Alterations and extension to conservatory, first floor side extension, balcony area at first floor, alteration of windows on rear first floor to create Juliet balconies, balcony doors & new window on ground floor side elevation.

Anchors Cast 2 Fosters Close Rustington

Thank you for your internet representation made on 24th July 2019 which has been recorded as '**an objection**' with the comments as follows:

Drawing Title:
Proposal Plans 15

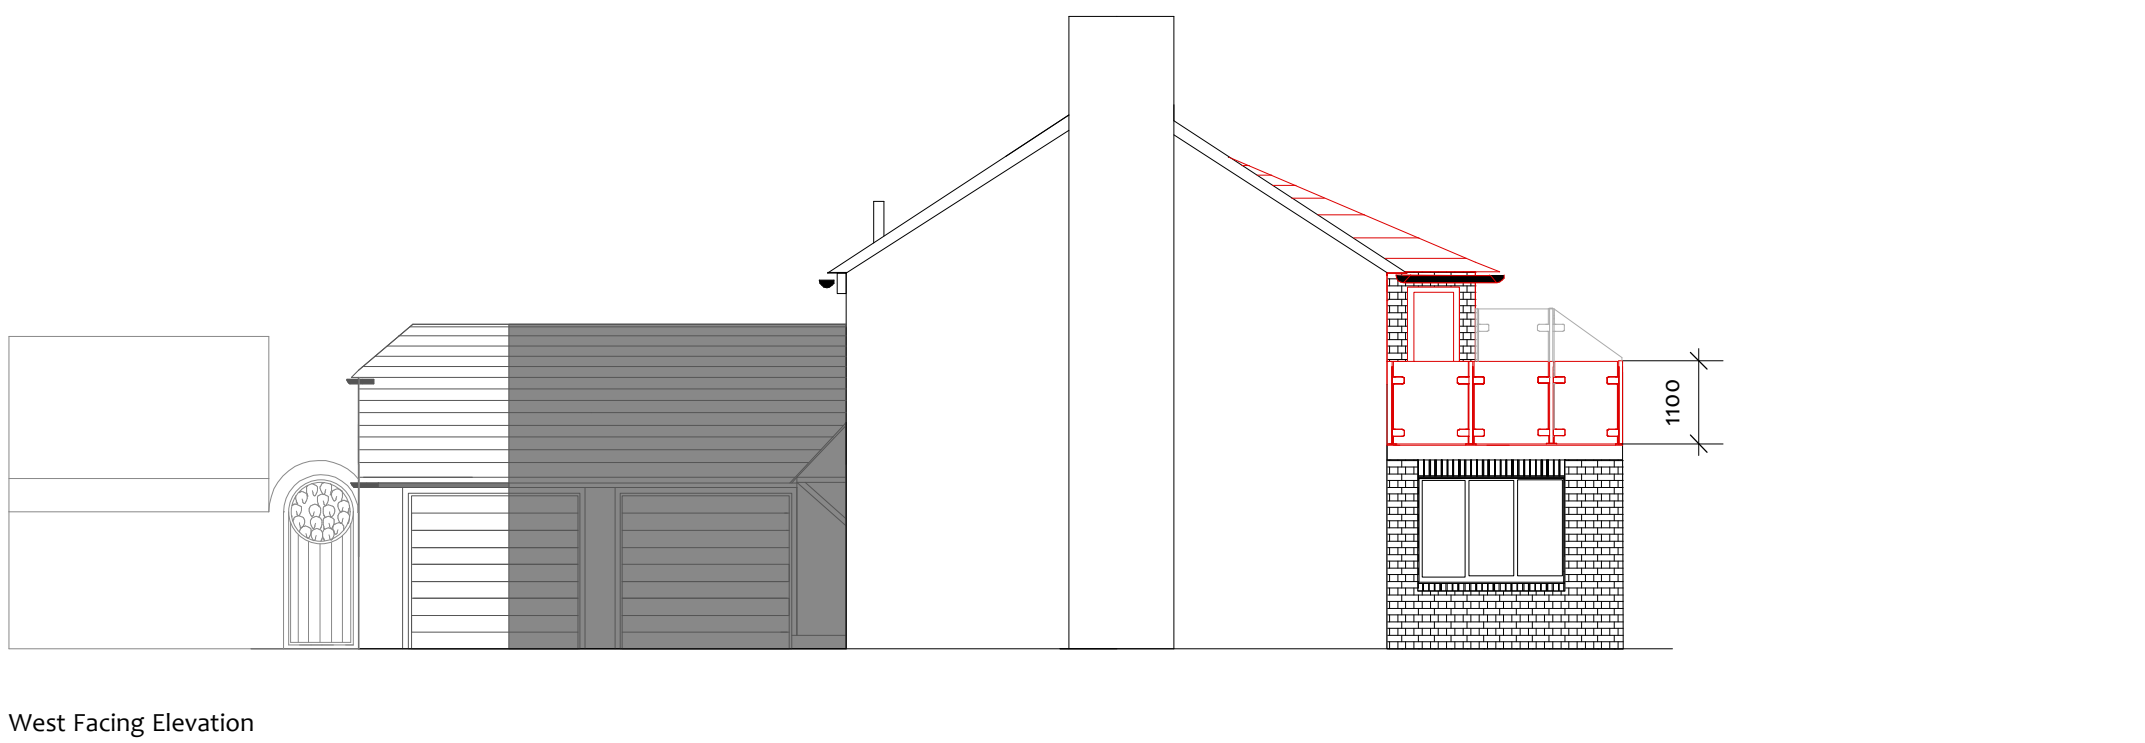
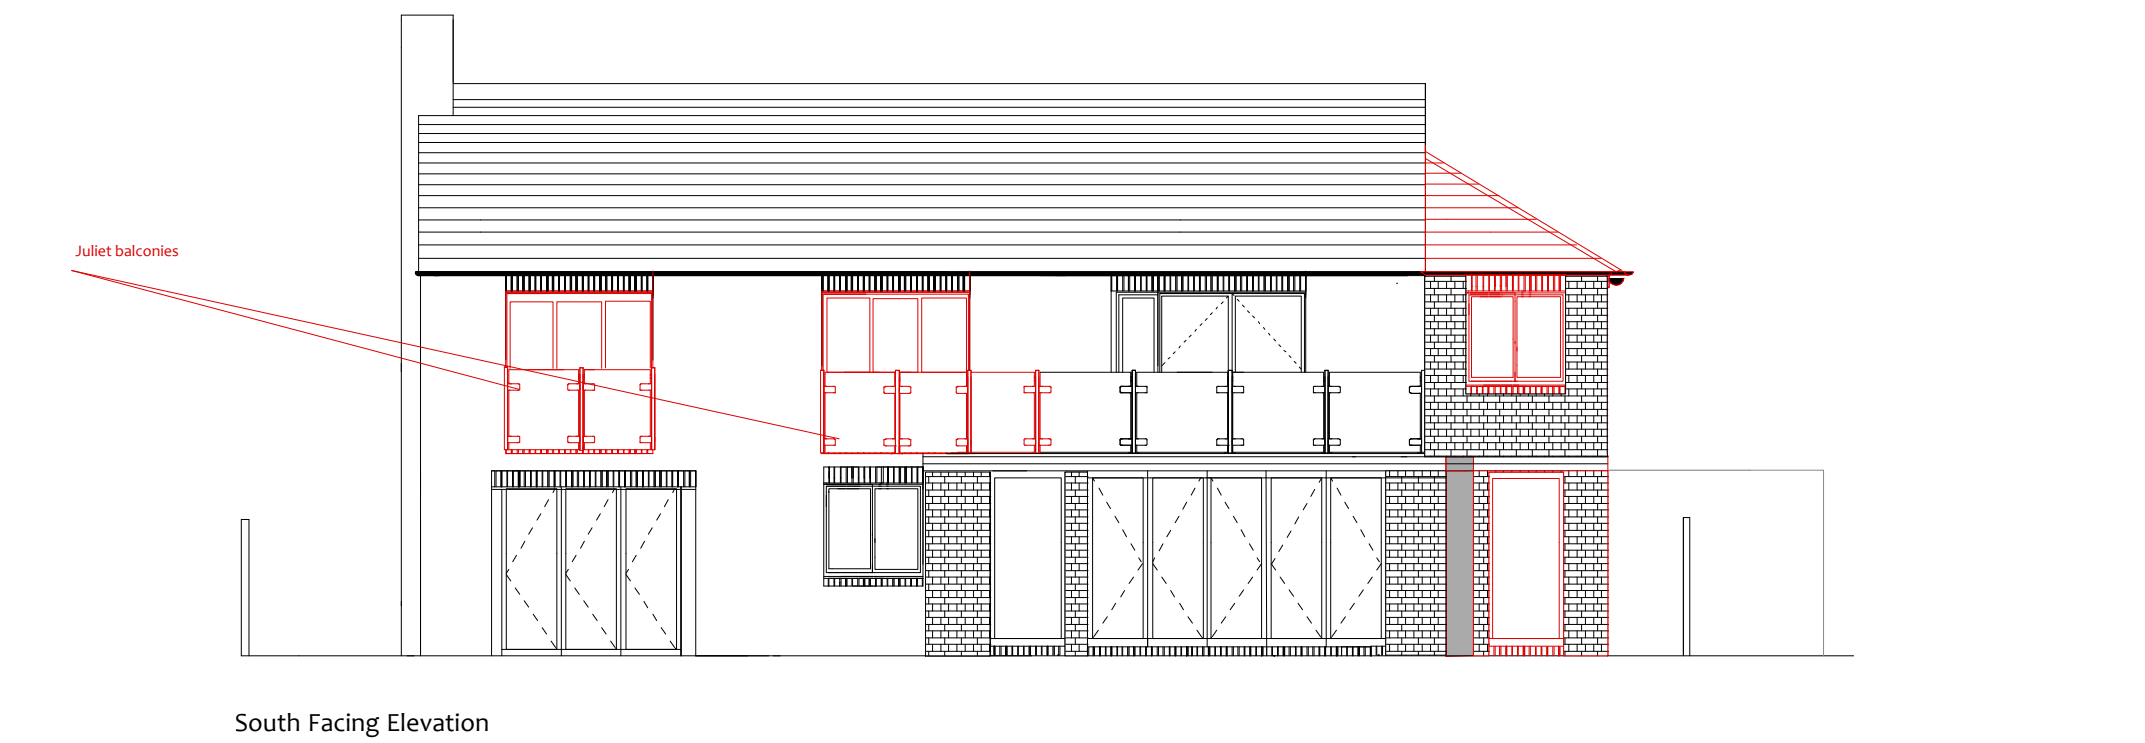
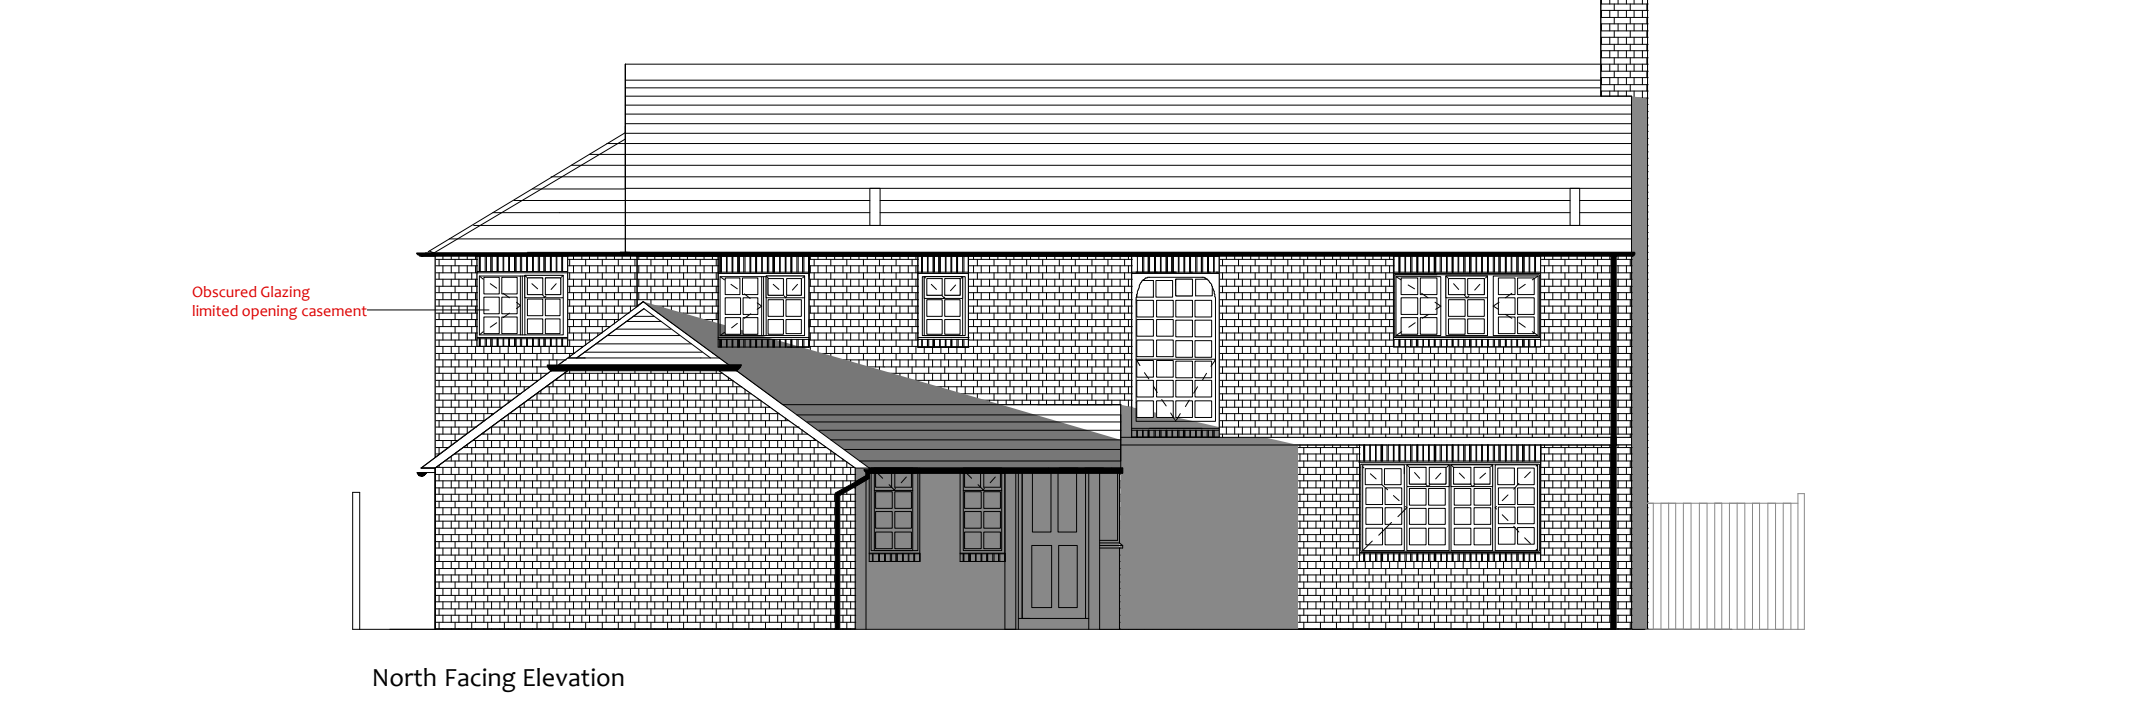
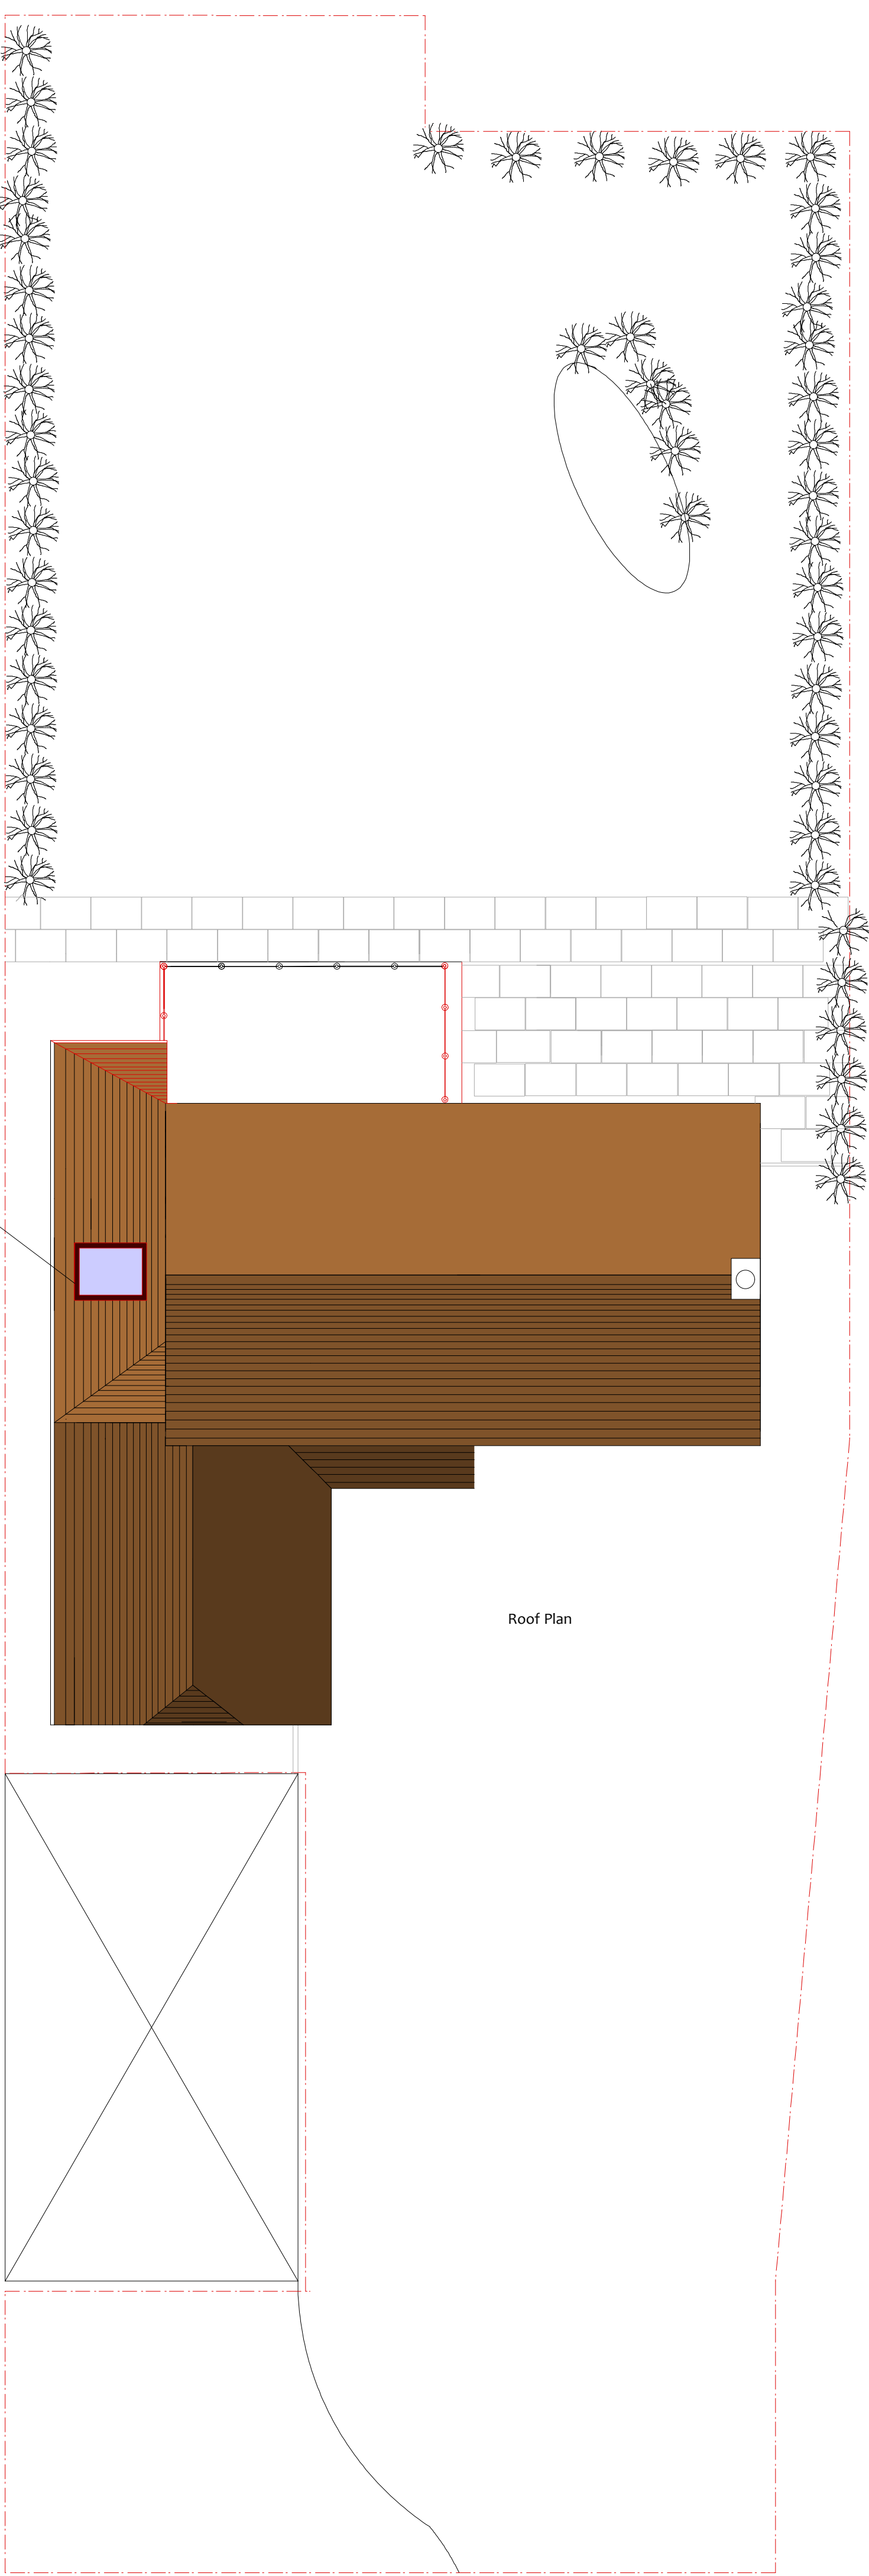
Whilst the proposed extension has been reduced in size, it still extends beyond the southern line of the main existing building to which we object. We have no objection to a low screen to the Eastern side of a balcony which extends beyond the existing building line.
